Case Officer: Jordan Campbell

Recommendation: Approve

Applicant: Samantha Nicol

Proposal: Single storey rear extension, new front dormer, alterations to front elevation and internal modifications

Drawing Title: Proposed Elevations		RIBA		T: 01865 699990	
Project Number: 209	Drawing Number: P130	Current Revision Letter: A	Drawing Scale: 1:100	Paper Size: A3	Drawn by: DP
				Checked by: RA

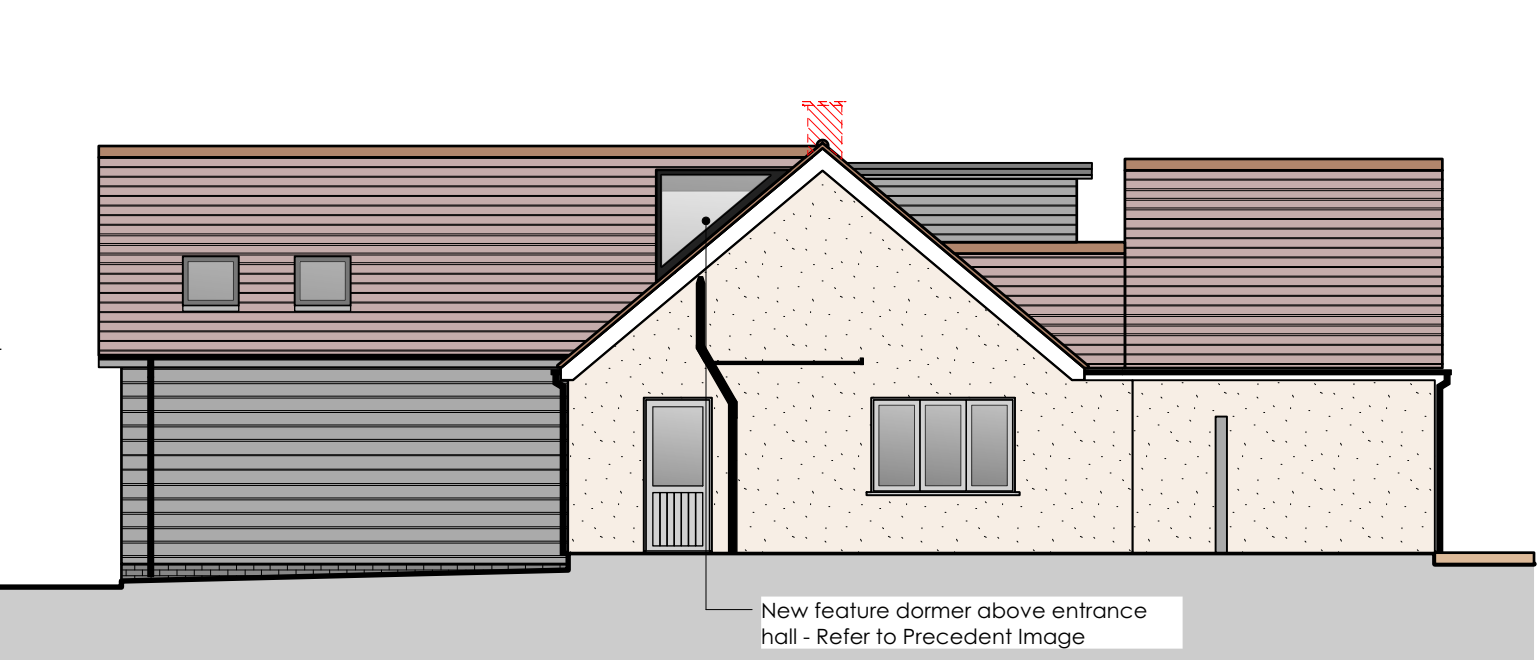
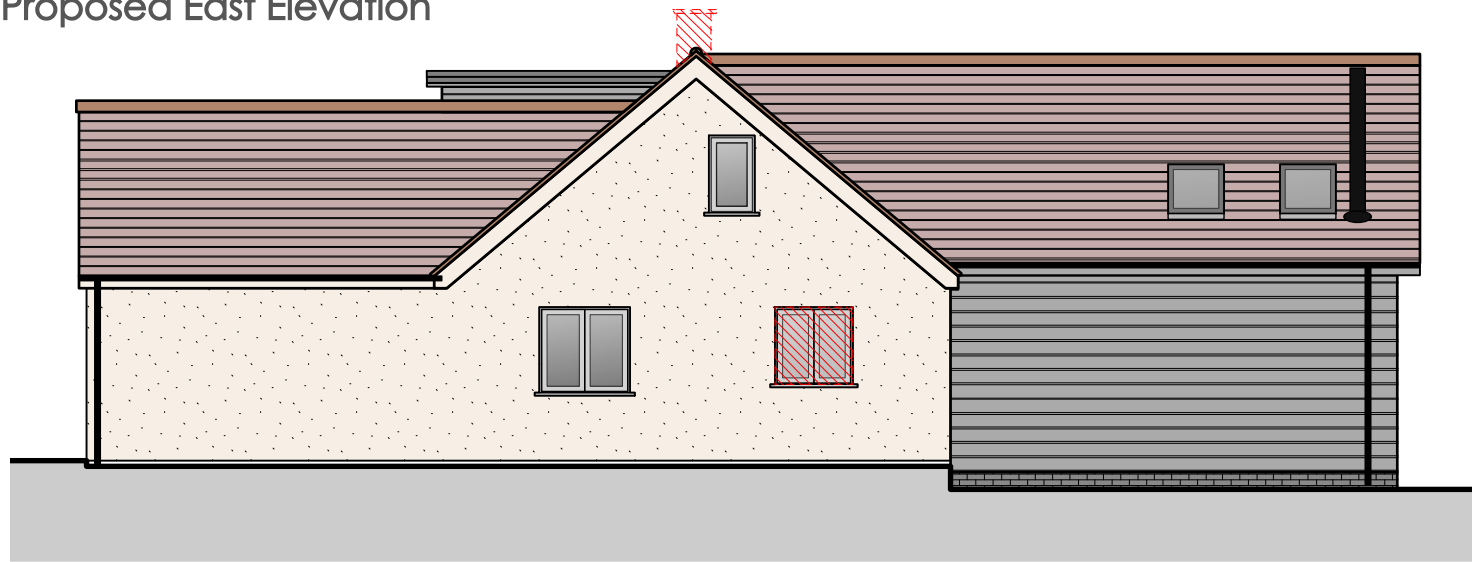
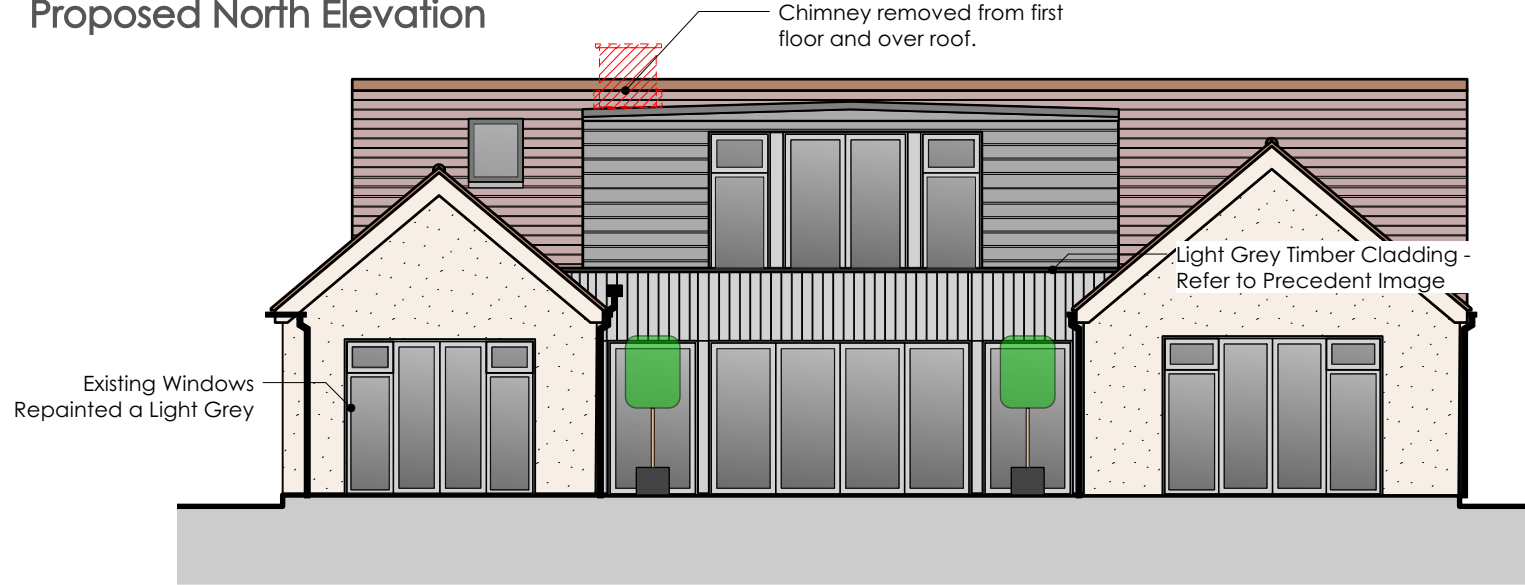
- The proposed single storey rear infill extension would not be visible from the public domain, as it would be fully screened behind the host dwelling. Thus, the proposed development would not result in any adverse impact to the character of the locality.

- Moreover, No.5 Park Close has benefited from a single storey front extension and flat roofed rear dormer externally finished in grey timber cladding. Thus, the proposed rear infill extension's form and grey timber cladding would not result in any notable adverse impact to the site's visual amenity, and would respect the context.

- The proposed rear extension would be adequately subservient by virtue of being sited to the rear and stepped down 3m from the ridge line of the main dwelling.

- Whilst the proposed box dormer to the main dwelling's front roof slope would be clearly visible from the public domain, any adverse impact to the character of the site or locality from the proposed box dormer would be somewhat mitigated through the proposed dormer being set down 0.5m from the ridge line of the main dwelling and in from the eaves, and due to the dormer's moderate scale, as the proposed dormer would not result in making the property appear visually top-heavy.

- The proposed grey timber cladding to the main dwelling's principal elevation, whilst unfortunate, would respect the context, and as such would not result in any notable adverse impact to the character of the site or locality. It would not set a precedent for other dwellings in the vicinity to carry out similar works.
